**United Utilities Water Limited
Planning, Landscape and Ecology**
2nd Floor, Grasmere House
Lingley Mere Business Park
Lingley Green Avenue
Warrington
WA5 3LP

Your ref: 3/2020/0309
Our ref: DC/20/1859
Date: 23-JUN-20

Location: Spout Farm Preston Road Longridge PR3 3B
Proposal: Erection of 34 dwellings and associated works

With regards to the above development proposal, United Utilities Water Limited ('United Utilities') has had further opportunity to review the Construction Management Plan and wishes to provide the following comments in addition to those in our previous letter dated 2nd June 2020.

**PROPOSED RESIDENTIAL DEVELOPMENT  
SPOUT FARM, LONGRIDGE  
SITE LOCATION PLAN**

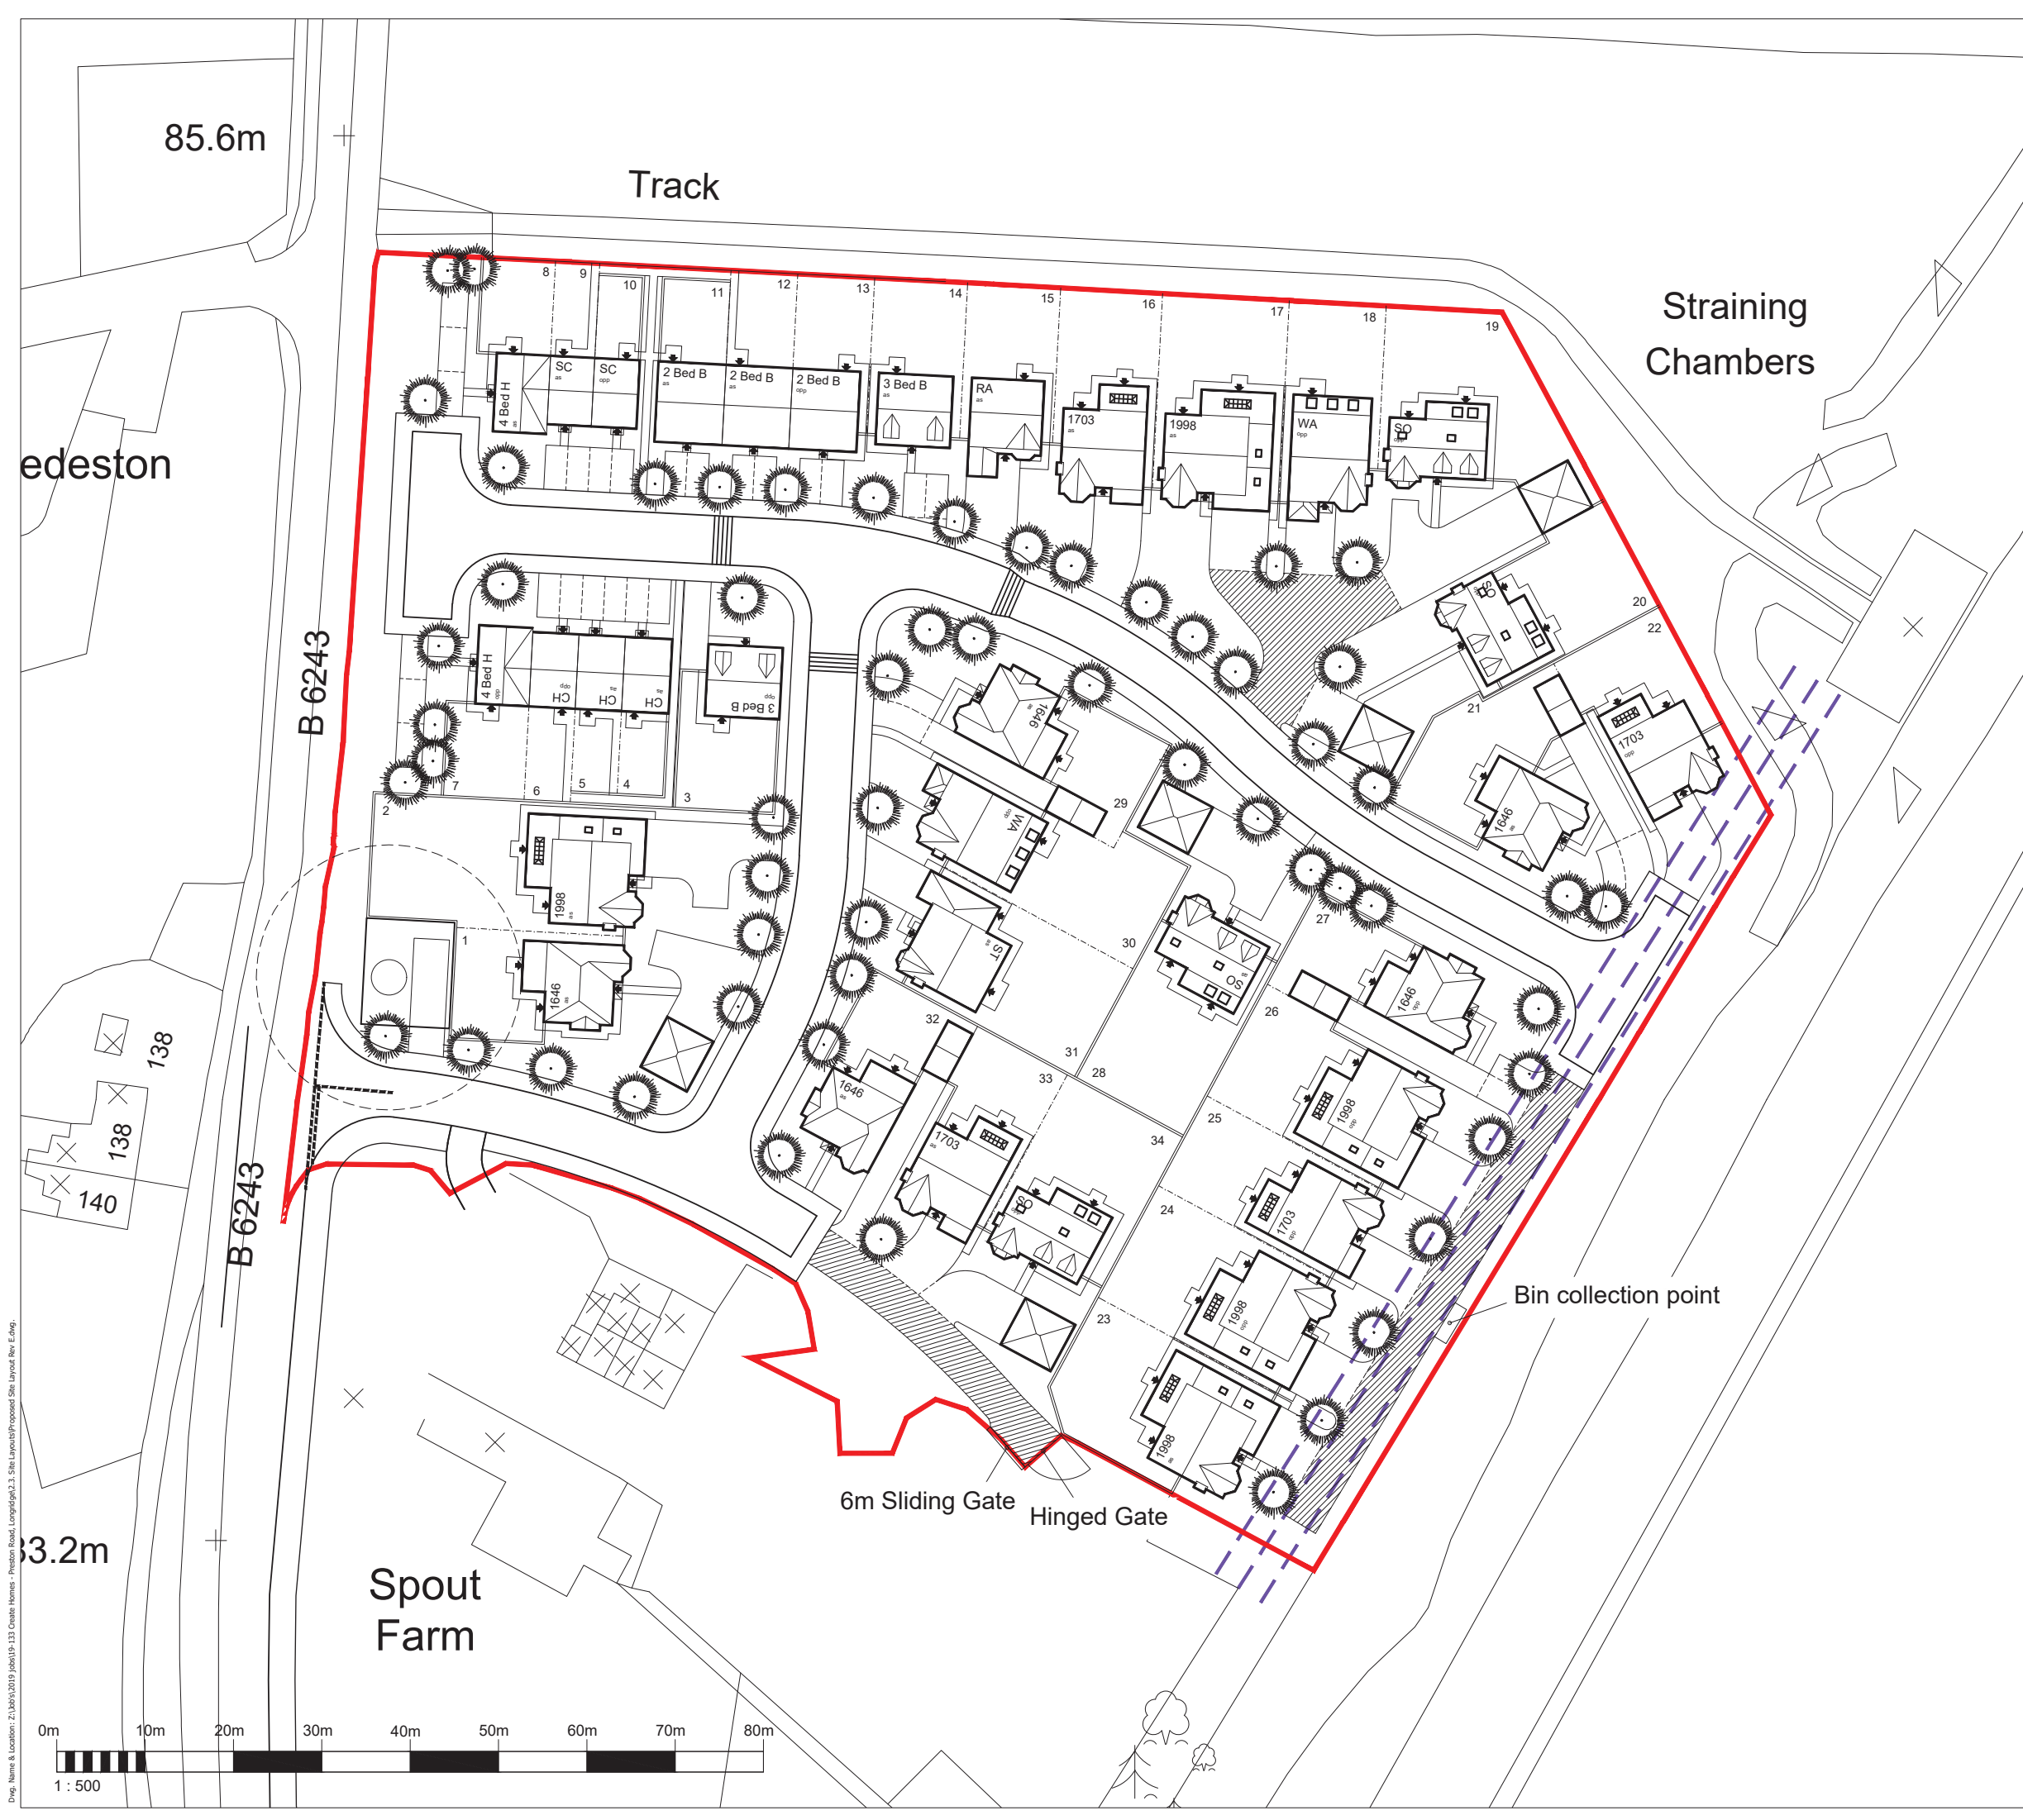
We can see from the proposed site layout that the water main would be located under a proposed roadway to access the plots to the eastern side of the site. It is critical that we are able to access our water main for essential maintenance and that it is afforded appropriate protection both during and after construction. The movement of heavy plant on-site must be carefully considered, there should be no significant land movement/excavation and landscaping proposals must select suitable species. Further guidance can be found in our Standard Conditions for Works Adjacent to Pipelines attached.

It is also essential that this raw water main is protected from pollution. Care should be taken regarding the location and method of storage of fuels and other potential pollutants during construction. Plant/machinery should not be parked in this area.

The construction management plan submitted does not provide any detail with regard to how the development is to be constructed to ensure the above, and we therefore require communication from the applicant (either as an amendment to the existing Construction Management Plan, or as a separate document) as to how they intend to develop the site, whilst ensuring access to and protection of the water main running through it.

Condition: Construction of the approved development shall not commence until details of the means of ensuring continued access to the the existing raw water main, and protection of the main from consequential damage and pollution during both construction and operation, have been submitted to and approved in writing by the Local Planning Authority. Any required measures identified shall be implemented in full accordance with the approved details.
